WEST SUSSEX COUNTY COUNCIL CONSULTATION

TO:	Arun District Council FAO:M Tomalova
FROM:	WSCC - Highways Authority
DATE:	12 July 2021
LOCATION:	14 Princess Avenue Bognor Regis PO21 2QT
SUBJECT:	AW/164/21/OUT Outline application with some matters reserved (landscaping) for the proposed conversion of existing dwelling into 4 No. flats to include single & two storey rear extensions & first floor extension over garage (resubmission following AW/251/20/OUT). This site is in CIL Zone 4 (Zero Rated) as flats.
DATE OF SITE VISIT:	n/a
RECOMMENDATION:	Advice
S106 CONTRIBUTION TOTAL:	n/a

Proposed Site Layout Plan at 1:100 scale

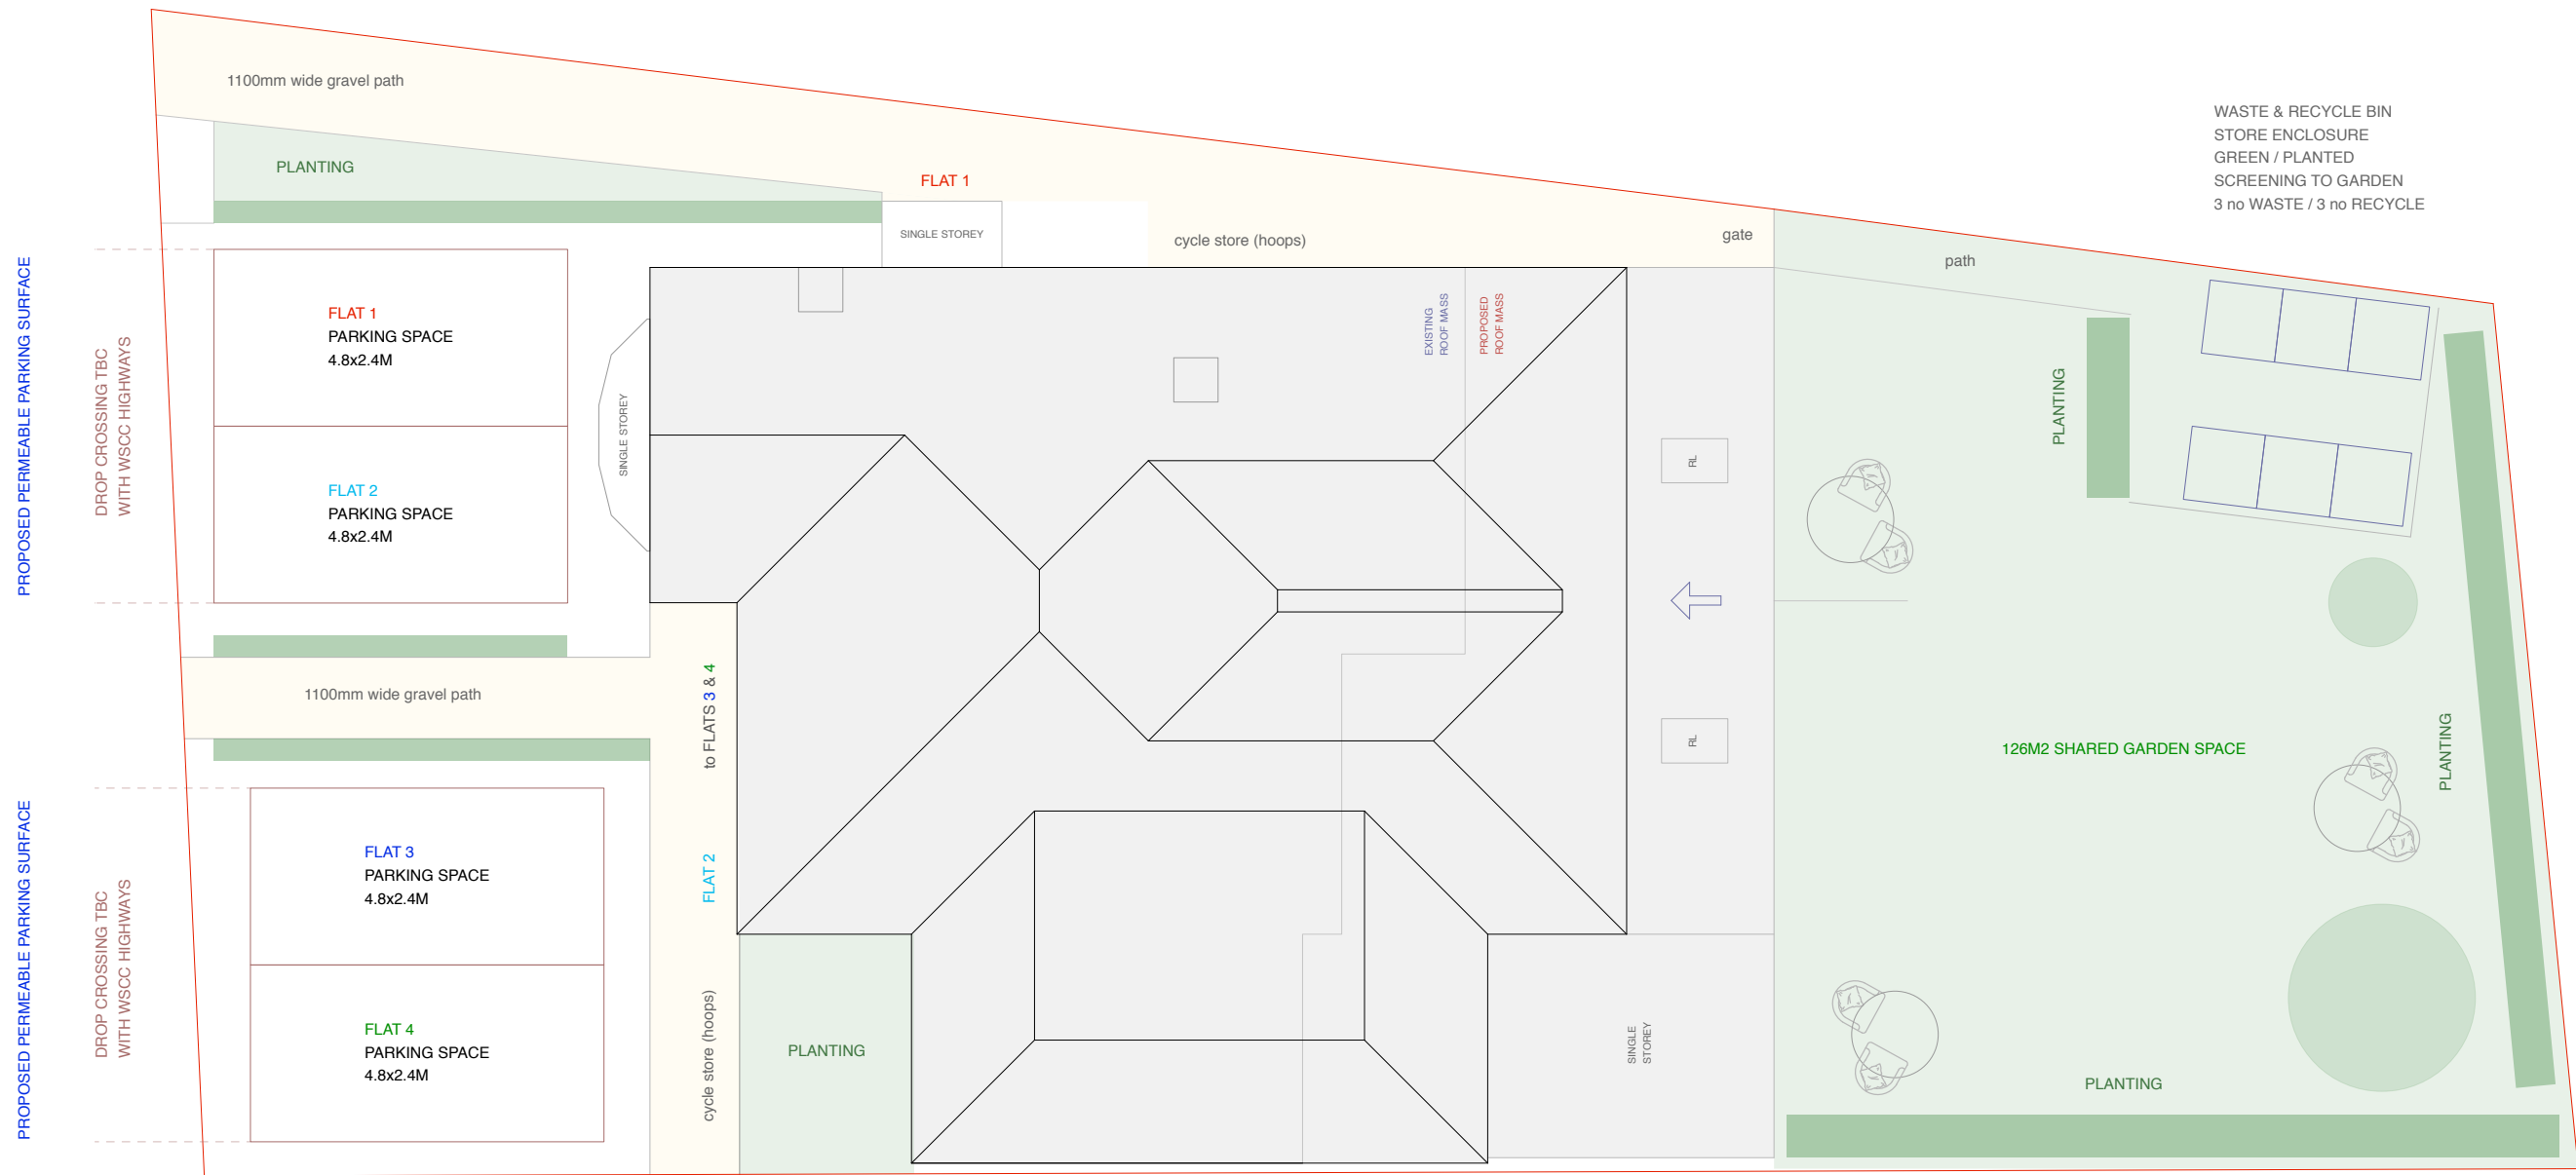
The proposed site plan demonstrates a 1.1m gravel path adjoining the public footpath. It should be noted that a gravel trap or other bound material should be provided where the access adjoins Princess Avenue to prevent the material being dispersed onto the public highway. The gravel trap must be positioned within the applicant's land and not the publicly maintained highway.

In order to promote the use of the sustainable transport methods, covered and secure cycle storage should be provided for the new flats. The proposed site plan annotates cycle store hoops style and these details are acceptable.

No development shall be first occupied until the vehicular access serving the development has been constructed (including a bound material from the back edge of the Highway boundary to prevent gravel overspill) in accordance with the approved Site Layout Plan.

No part of the development shall be first occupied until covered and secure cycle parking spaces have been provided in accordance with the approved Site Layout Plan.

No part of the development shall be first occupied until the car parking has been constructed in accordance with the approved Site Layout Plan. These spaces shall thereafter be retained at all times for their designated purpose.
